17 April 2026

Mount Pleasant Mine (MOD8) - Muswellbrook Shire Council comments on the Modification Report

- 'Mount Pleasant Operation Modification 8 – Modification Report' (Resource Strategies) (Modification Report); and
- Request to provide comment on the Modification Report via the Major Projects Portal.

MACHEnergy MOUNT PLEASANT OPTIMISATION PROJECT Conceptual Final Landform

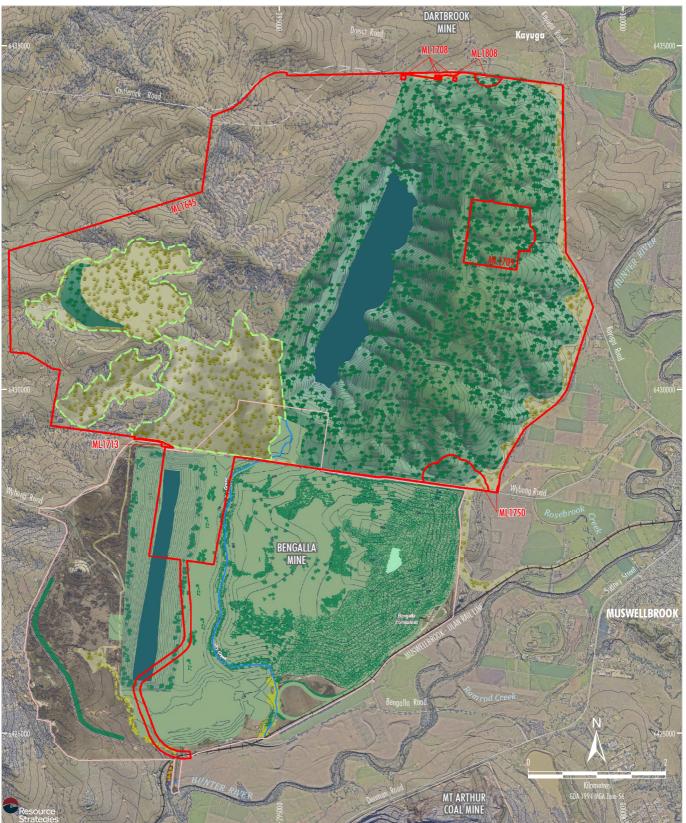
9. Section 3.12 of the Modification Report states that ‘the final void would be shaped to reflect a less engineered profile that is more consistent with the surrounding natural environment’. Council does not agree that MACH has designed the final void/s in accordance with this commitment and has concerns regarding the proposed landform shape and overall geometry of the two interconnected final voids in the South Pit and North Pit. The current configuration does not reflect a natural landform outcome and appears highly engineered, particularly in the North Pit where the proposed void geometry forms an unnatural Y-shaped profile with straight, steep edges that do not integrate with the surrounding landscape. Further consideration is required to reshape the final voids to achieve a more natural profile that better integrates with the surrounding landscape.

10. The shape and geometry of the proposed final voids also do not align with contemporary best-practice final void rehabilitation approaches in the region. For example, the Rix’s Creek North Continuation Project (SSD-60774228) proposes the use of alternate mining methods to create landforms shaped as shallow grassy depressions without high walls in the final landform. Council requests MACH consider opportunities to reduce the height of the out-of-pit emplacement areas through additional backfilling of final voids, particularly the North Pit void.

11. DA 92/97 allows for landform elevations up to approximately 320 metres Australian Height Datum (AHD) (Section 1.2.9). While Section 6.14.2 of the Modification Report states that the proposed MOD8 final landform heights would be ‘lower in comparison to SSD 10418’, clarification is required regarding the maximum final landform heights proposed under MOD8 relative to those currently approved under DA 92/97.

12. Clarification is also required regarding whether highwalls would remain as part of the final landform and the maximum slopes proposed for the rehabilitated landform.
